Our ref: HA/2020/121925/01
Your ref: EN020022

Date: 19 February 2020

Application by AQUIND Limited for an Order Granting Development Consent for the AQUIND Interconnector.

Relevant Representation on behalf of the Environment Agency

TITLE:
**Figure 19.4
Source Protection Zones
Sheet 1 of 3**

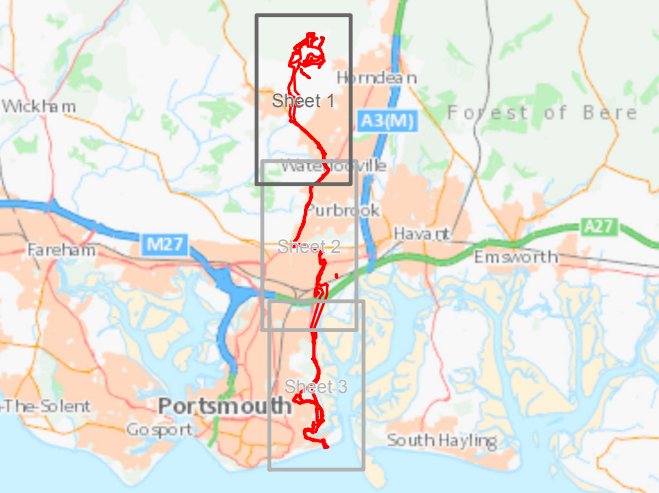
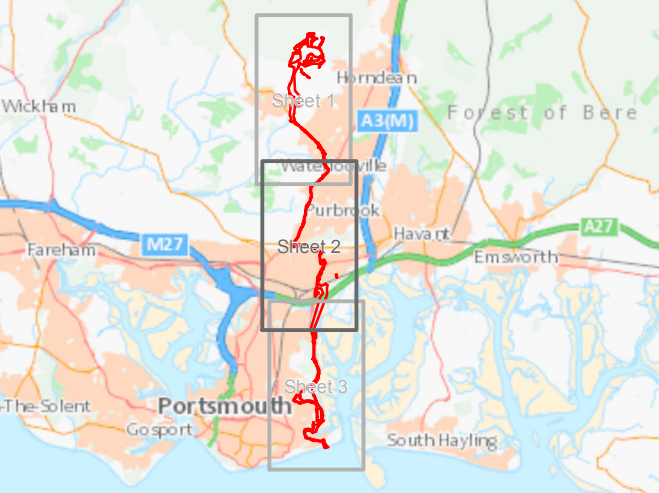
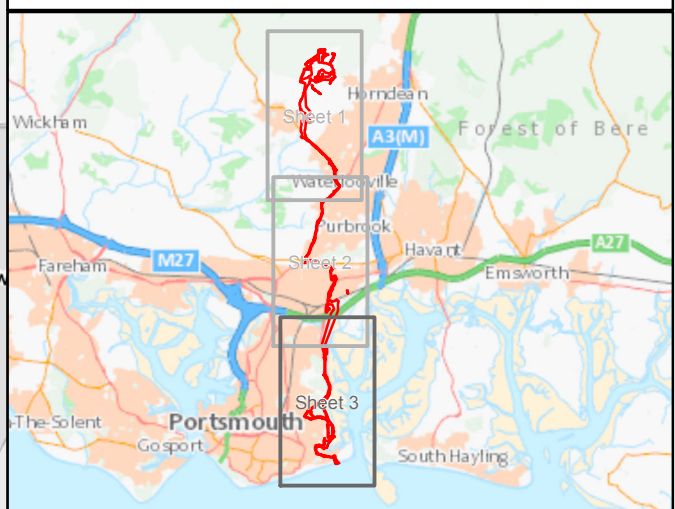
- Protection of sensitive groundwater at the site of the converter station at Lovedean. The site is located within the Bedhampton and Havant Springs Source Protection Zone 1 (see **Figure 19.4 of Document Ref 6.1.19** (Environmental Statement - Volume 1 - Chapter 19 Groundwater)). The groundwater is utilised by Portsmouth Water to provide public water supplies to around 250,000 homes. There are known to be karstic features present within the underlying bedrock in the converter station area. Karstic features can form when water dissolves channels and flow paths in an underlying bedrock. These can result in very rapid direct pathways for contaminants to underlying sensitive geology. Therefore, the protection of groundwater at this location from the risk of pollution both during construction and operation of the converter station is of paramount importance.
